**KIRKLEES METROPOLITAN COUNCIL
INVESTMENT & REGENERATION SERVICE**

DELEGATED DECISION TO DETERMINE PLANNING APPLICATIONS

Reference No:	2022/62/91725/W
Site Address:	3, Holly Road, Thornton Lodge, Huddersfield, HD1 3SE
Description:	Erection of two storey rear extension and front dormer
Recommending Officer:	John Holmes

HOUSEHOLDER DELEGATED REPORT

AS EXISTING

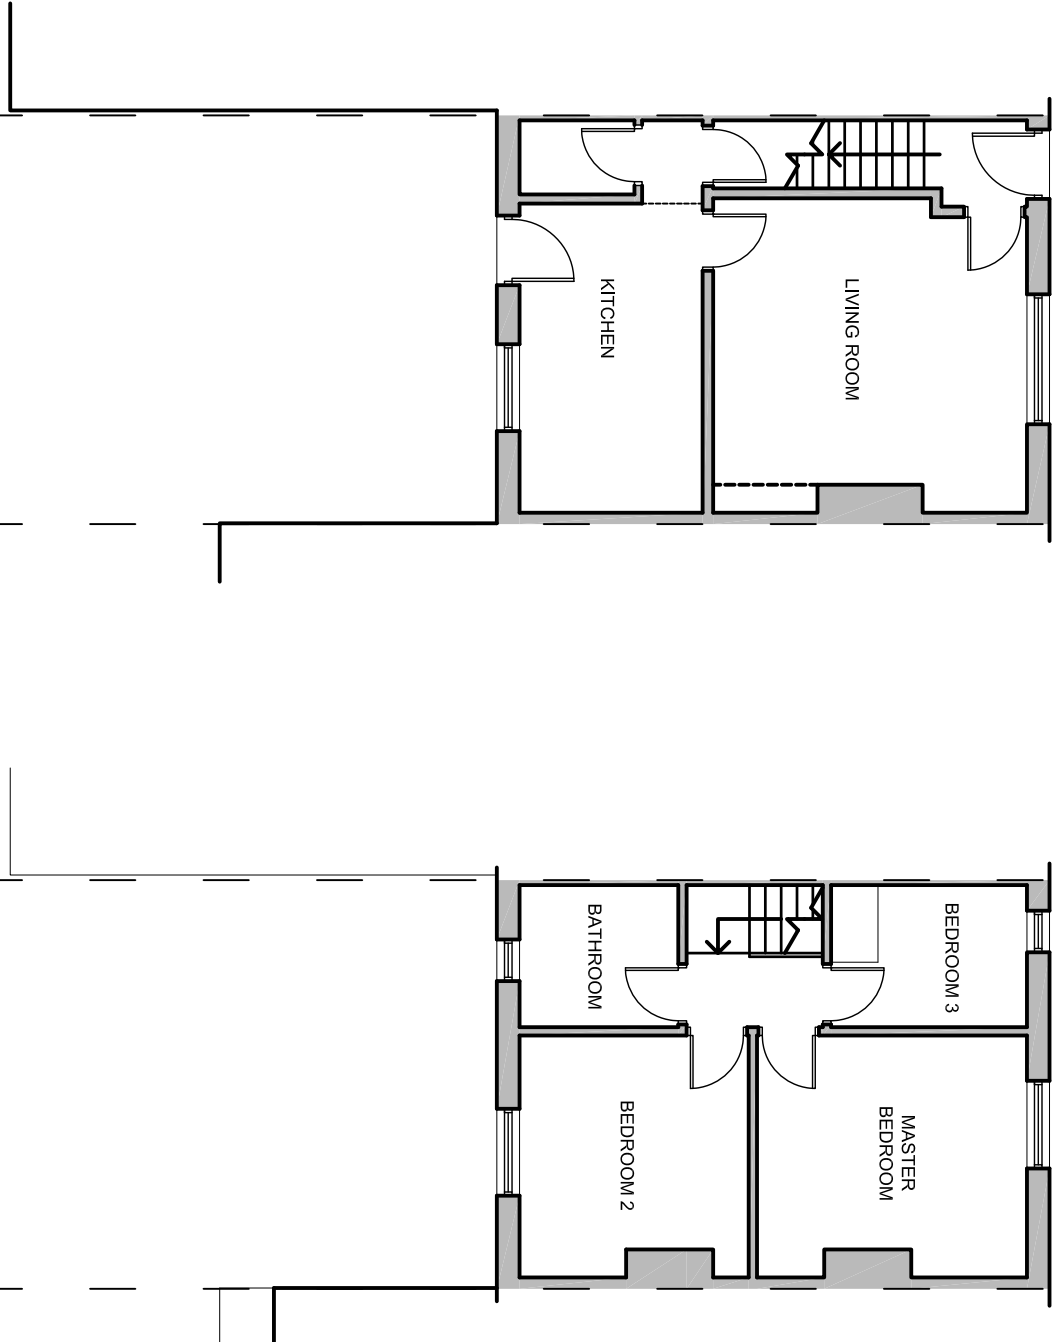
<u>Two Storey Rear Extensions should:</u>	<u>Yes - COMPLY</u>	<u>No - JUSTIFY</u>
be proportionate to the size of the original house and garden;		The extension is to the rear and although sizeable it is in keeping with the style, scale and design of an extension to the adjoining property (no.1) which is of an identical design.
not normally exceed 50% of the total area of land around the original house (including previous extensions and outbuildings);	The extension would not cover more than 50% of the amenity space serving the dwelling.	
not project out more than 3 metres from the rear wall of the original house or by 4 metres for detached properties;		The extension does exceed this at the ground floor level, although it is in keeping with the style, scale and design of an extension to the adjoining property.
not exceed a height at the eaves of 3 metres where the extension is within 1.5 metres of the property boundary;		The extension does exceed this although it is in keeping with the style, scale and design of an extension to the adjoining property.

be separated from the property boundary, such as a wall, fence or hedge, by at least 1.5 metre;		The extension does not achieve this although it is in keeping with the style, scale and design of an extension to the adjoining property.
not adversely affect habitable room windows where they adjoin a neighbour's boundary.	The extension is considered to meet this requirement.	
<u>Dormer windows should:</u>		
relate to the appearance of the house and existing roof	The dormer is set in from the sides, back from the eaves and below the

ridge of the host property. It is considered to acceptably relate to the appearance of the dwelling / roofslope.	
be designed in style and materials similar to the appearance of the existing house and roof	The dormer would be finished in a similar colour	
not dominate the roof or project above the ridge of the house	The dormer is considered to meet this requirement.	
be set below the ridgeline of the existing roof and within the roof plane	The dormer is considered to meet this requirement.	
be aligned with existing dormer windows on neighbouring properties in the same roof plane where relevant	The scale of the dormer and its siting in the roof slope is similar to that of an extant consent for the adjoining property which could still be implemented.

Relevant key design principle (KDP) of the SPD, Policy in the Kirklees Local Plan and the NPPF	Further comments	✓ / X / N/A
Impact on the Local character and street scene	- KDP1 of the SPD - Policy LP24 Design (a) and (c) of the KLP	The two storey rear extension is visible from the highway to the east of the site, although will be in keeping given the adjoining property's extension to rear	✓

Chapter 12 NPPF	(no.1) which the proposal would be of a similar design. The dormer to front would be of a similar design to that of an extant consent in place at the host property and adjoining property. The impact is concluded to be acceptable.	
Impact on original house	- KDP2 of the SPD - Policy LP24 Design (c) and (d) of the KLP - Chapter 12 of the NPPF	The proposal would not significantly erode the character of the original dwelling and is considered acceptable in this regard. This takes into account the quantum of development to no. 1	✓
Height, scale and massing	- KDP 1 and 2 of the SPD - Policy LP24 Design (a), (c) and (d) of the KLP - Chapter 12 of the NPPF	The height, scale and massing of the development is considered to be in keeping to the host dwelling taking account of previously implemented development to the adjoining dwelling at no. 1 of which the host property forms a pair	✓

Facing materials and detailing	- KDP 9 of the SPD - Policy LP24 Design (d) (iii) of the KLP - Chapter 12 of the NPPF	The materials would harmonise with the materials palette of the original dwelling. This would be brick and tile to match the existing and dark cladding to the dormer	
Roof style	- KDP 1 and 2 of the SPD - Policy LP24 Design (a), (c) and (d) of the KLP - Chapter 12 of the NPPF	This is considered to be in keeping with that of the adjoining dwelling and as such is considered to be acceptable in this case. The dormer would harmonise with that at no. 1	✓
Window proportions	- KDP 1 and 2 of the SPD - Policy LP24 Design (a), (c) and (d) of the KLP - Chapter 12 of the NPPF	These are considered to be in keeping with the locality and host property.	✓
Accessibility for all users	KDP 17 of the SPD	The proposal would be suitably accessible.	✓

Relevant key design principle (KDP) of the SPD, Policy in the Kirklees Local Plan and the NPPF	Further comments	✓ / X / N/A
Impact on privacy of neighbours (to sides, rear and front)	• KDP 3 & 4 of the SPD • Policy LP24 Design (d) (iv) • Chapter 12 of the NPPF	No openings in the side that would face 1 & 5 Holly Road. Openings to the rear would be nearer 42, 44 & 50 Yew Hill Road maintaining a distance of 19.5m at ground floor and 20.5m at first floor. This is in keeping with the existing arrangements in the locality and considered acceptable. The dormer to front is set back from the front elevation of the host property and is not considered to significantly increase overlooking over and above that which exists already in relation to properties opposite (4, 6, 12, 14 – 16 Holly Road)	✓
Impact on light and outlook of neighbours (to sides, rear and front)	• KDP 4, 5, 6 of the SPD • Policy LP24 Design (b) • Chapter 12 of the NPPF	No significant impact given distance from neighbours and fact no.s 1 & 5 Holly Road have large additions (ground floor only for no.5) and also the location of the window at first floor level to the rear of no.5.	✓

4. The cladding to the dormer hereby approved shall be dark grey. The cladding shall be applied to the dormer before the accommodation it serves is first brought into use. The cladding shall be retained as such thereafter.
